**Planning Act 2008 – Section 88 and the Infrastructure Planning (Examination Procedure) Rules 2010 – Deadline 7: 9.67 Quantifying Uncertainty in Entrapment Predictions for Sizewell C - Revision 1.0**

**Application by NNB Generation Company (SZC) Limited for an Order Granting Development Consent for the Sizewell C Project**

For Deadline 7 (3rd September) the Examining Authority (ExA) have requested comments on additional reports submitted by NNBSGenCo (SzC) Ltd at Deadline 6. We wish to provide feedback on the following report [REP6-028] Deadline 6 Submission - 9.67 Quantifying Uncertainty in Entrapment Predictions for Sizewell C - Revision 1.0

Figure 1 Observed number of herring impinged per 24 hour period at Sizewell B (from TR339 [AS-238]).

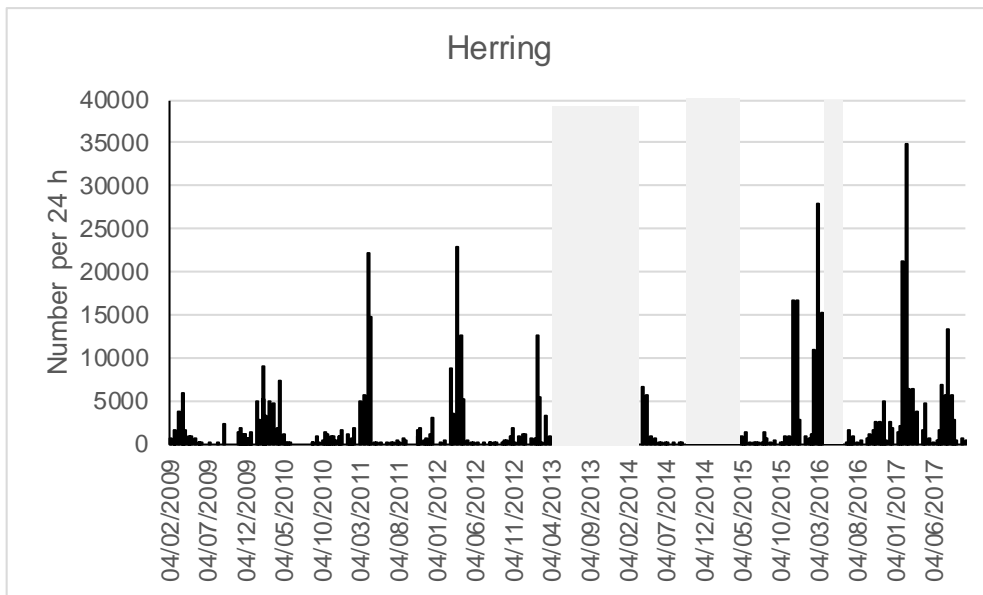
As we highlighted at Deadline 2, in our Written Representation [REP2-135], the true impingement rate at SZB is uncertain, as based on the CIMP data presented. The consequence of this is that the predicted impingement at SZC may have been underestimated and the impacts to species of relevance for the DCO application under the Environmental Impact Assessment Regulations 2017 and The Water Environment (Water Framework Directive) (England and Wales) Regulations 2017 may prove to be unacceptable.

The CIMP undertaken at SZB had frequent overflowing of the bulk overnight sample. On these occasions an incomplete bulk sample was collected, providing a 'greater than' result, or the bulk sample was abandoned and no result obtained. This means that more fish may

have been collected than recorded in the sampling. Results from overflowing bulk samples have been excluded from the data set, and impingement for surveys affected extrapolated from day-time hourly samples. Published evidence indicates that more fish are impinged at night than in the day at Sizewell A.

We consider a precautionary correction factor should be applied to account for this issue. This has not been provided and as such the magnitude and impacts of SZC impingement may well differ from those currently provided by NNBSGenCo (SzC) Ltd.
